Fire Marshal Division

Re: Lillington Hibachi
133 W. Cornelius Harnett Blvd.
Lillington, NC 27546

Application Number FMFW1901-0003

**SHEET NO.**  
 4

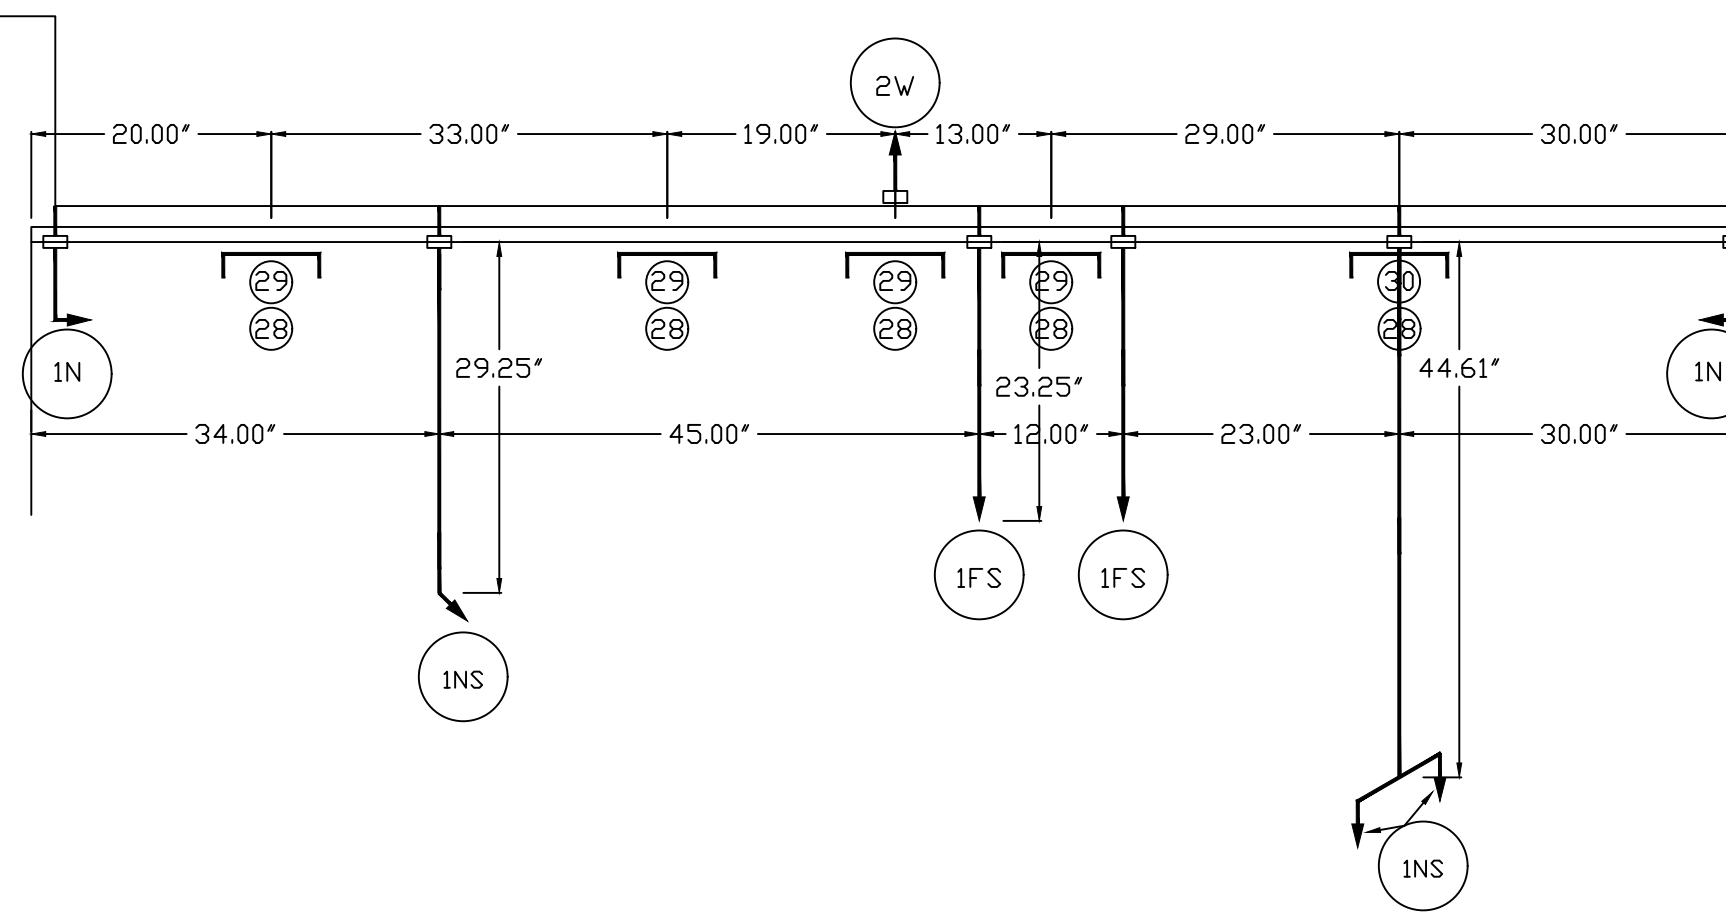
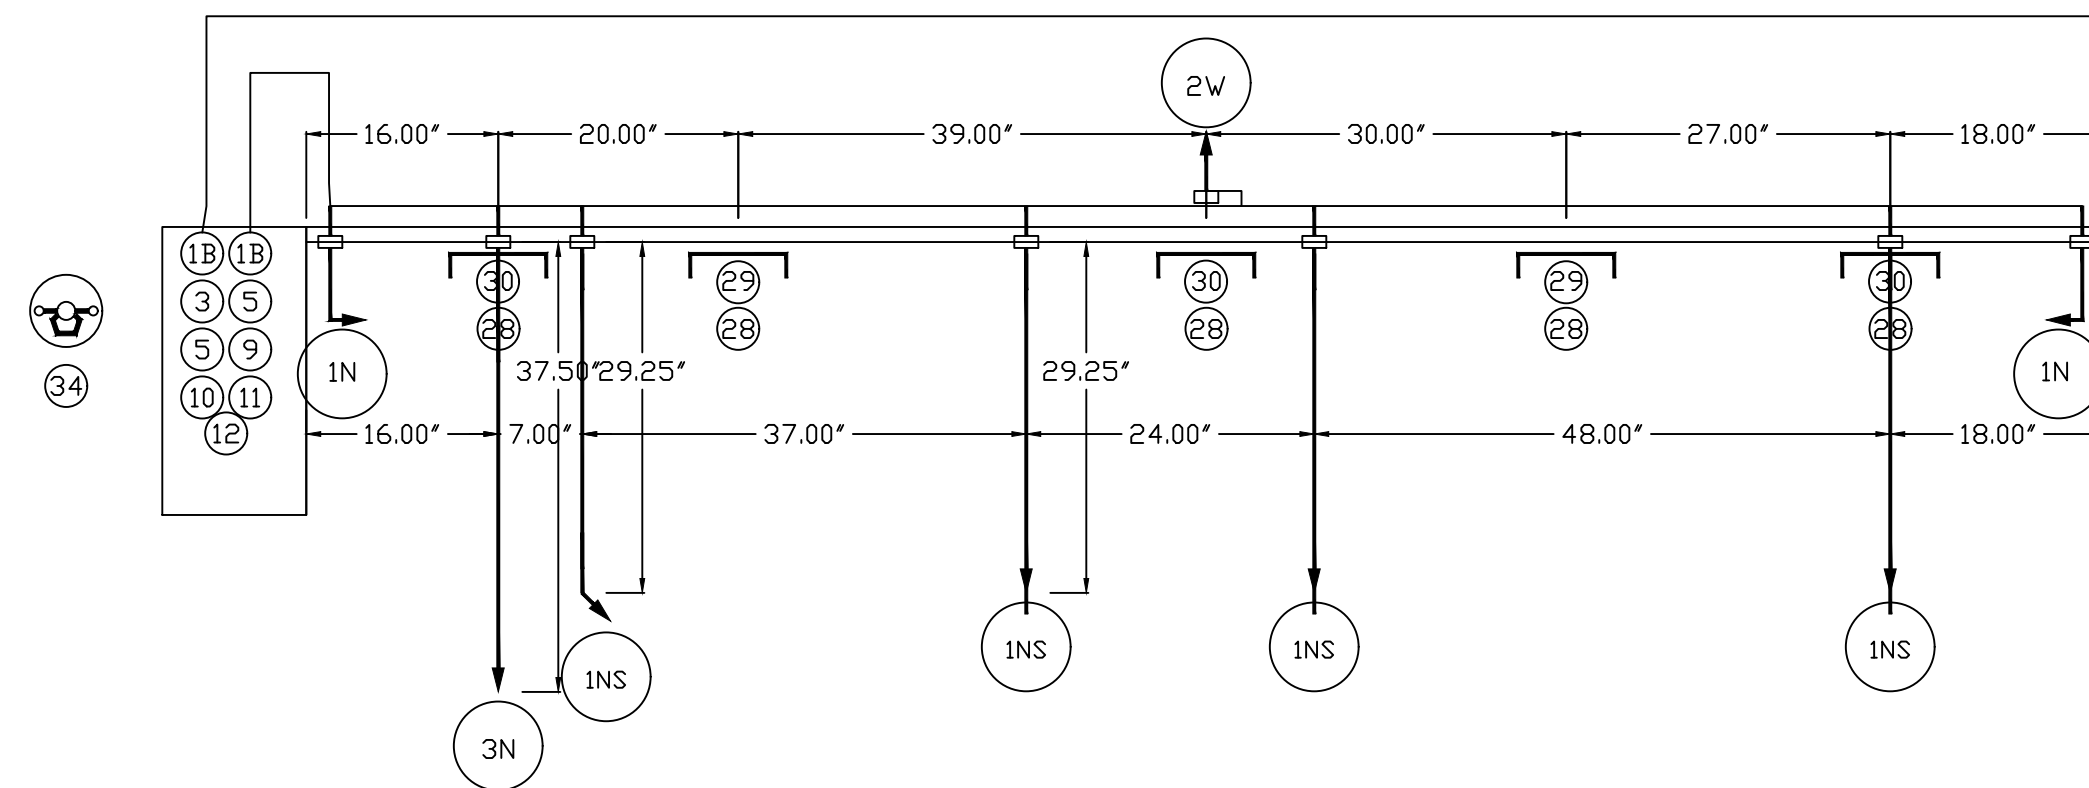
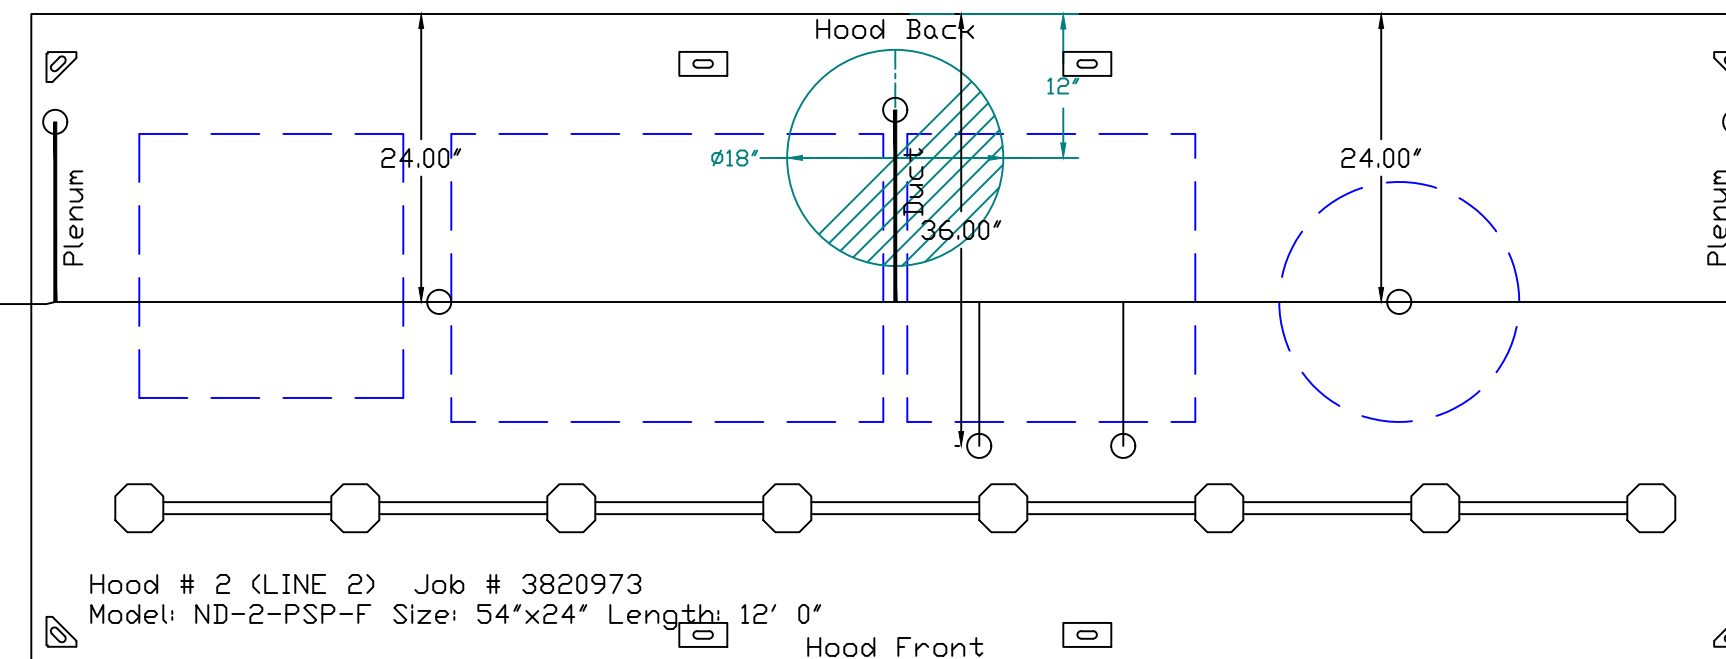
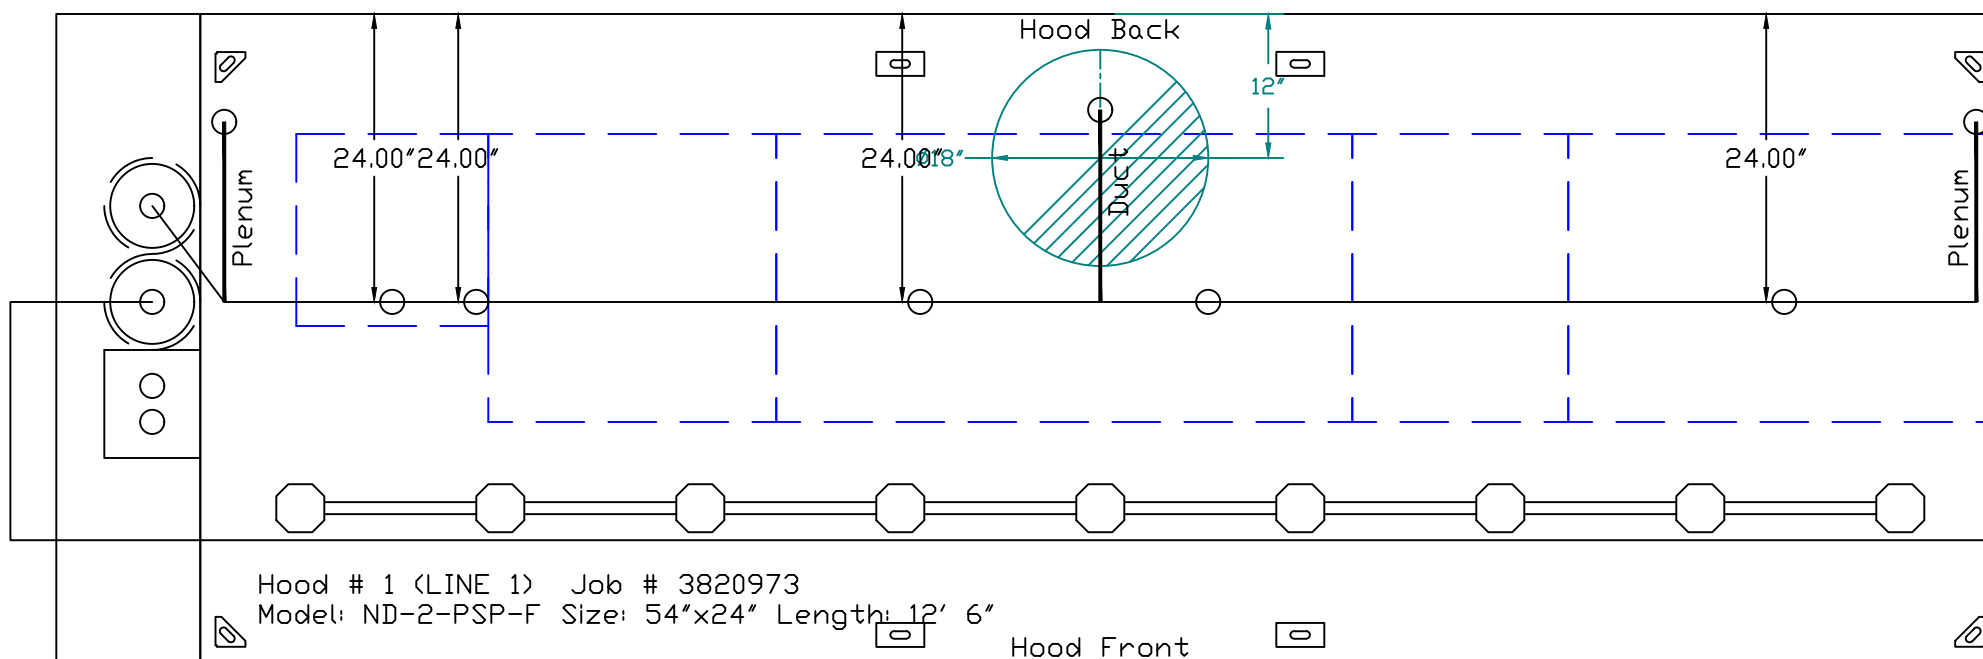
- **Commercial cooking equipment.**
 - Portable fire extinguishers shall be provided within a 30-foot (9144 mm) travel distance of commercial-type cooking equipment. Cooking equipment involving vegetable or animal oils and fats shall be protected by a Class K rated portable extinguisher.
- **Acceptance Test**
 - An acceptance test will be conducted by the Fire Marshal's office once system has been installed and pre-tested.
 - Installation shall be per architectural and system submittals and compliant with NFPA-17A.
- **Manual system operation**
 - A manual actuation device shall be located at or near a means of egress from the cooking area, a minimum of 10 feet (3048 mm) and a maximum

of 20 feet (6096 mm) from the kitchen exhaust system. The manual actuation device shall be located a minimum of 4.5 feet (1372 mm) and a maximum of 5 feet (1524 mm) above the floor. The manual actuation shall require a maximum force of 40 pounds (178 N) and a maximum movement of 14 inches (356 mm) to actuate the fire suppression system.

- **System Interconnection**

- The actuation of the fire suppression system shall automatically shut down the fuel or electrical power supply to the cooking equipment. The fuel and electrical supply reset shall be manual.
